From: Amanda Scholes on behalf of Planning.Responses
Sent: 30 January 2020 08:44
To: Planning Scanning
Subject: FW: 4 Lake Lane -ground infiltration rate. BN/59/19/DOC

From: Paul Cann <[REDACTED]>
Sent: 13 January 2020 12:00
To: Daniel Vick <[REDACTED]>
Subject: RE: 4 Lake Lane -ground infiltration rate. BN/59/19/DOC

I can now confirm the following comments in respect to the surface water drainage;

|        | 4 Lake Lane<br>Barnham<br>West Sussex | Surface water<br>drainage plan | Planning    | CB       | CB             |

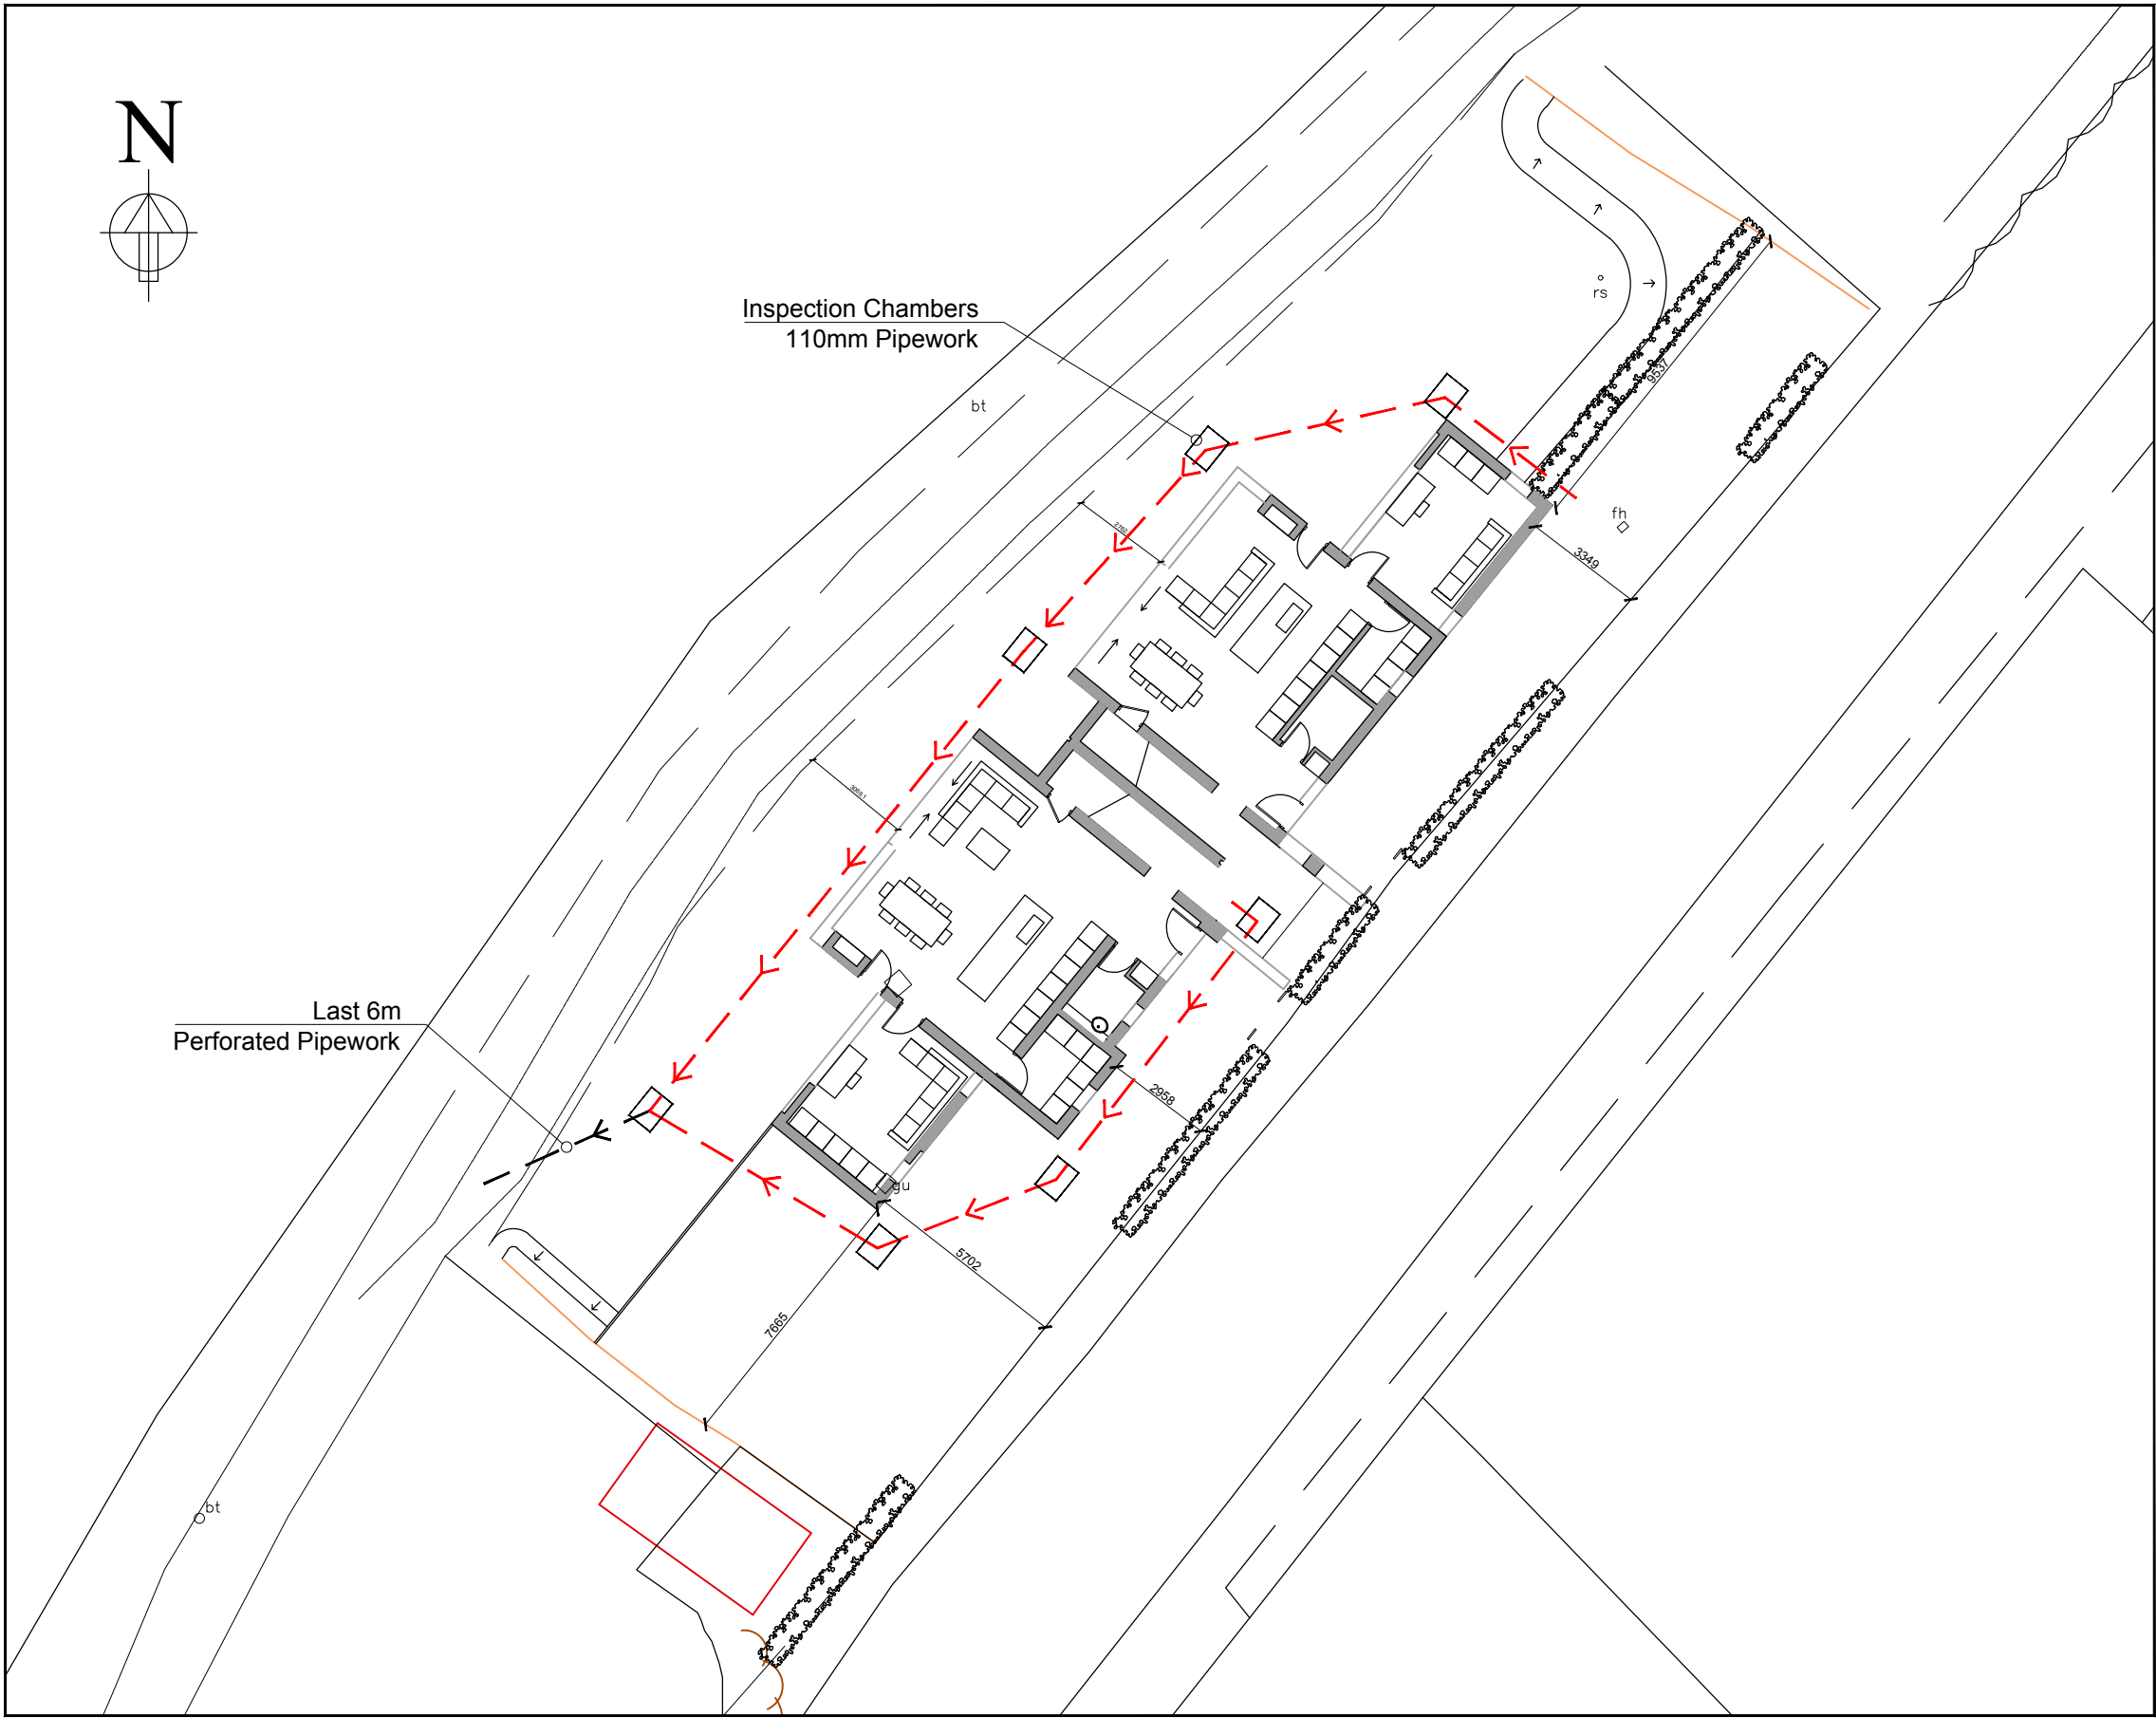
However, ground conditions observed at the time, the previous land use (a house that discharged direct to the rife) and the proximity of the Barnham Rife, we agreed that shallow perforated pipework is an option we would consider in this case. This would make use of any infiltration potential before discharge to the Barnham Rife. Groundwater monitoring/infiltration tests was agreed to be waived, provided we can agree the detailed proposals based upon site discussions. Needless to say, no proposals were submitted until now.

In terms of a way forward, I suggest the applicant amends their plan to show fully detailed arrangements. This should include manhole cover levels, invert levels, all pipe diameters and gradients. Construction drawings are also required for manholes, pipe bedding, bedding/spec for perforated pipe section, gravel finished area around the building frontage, etc.
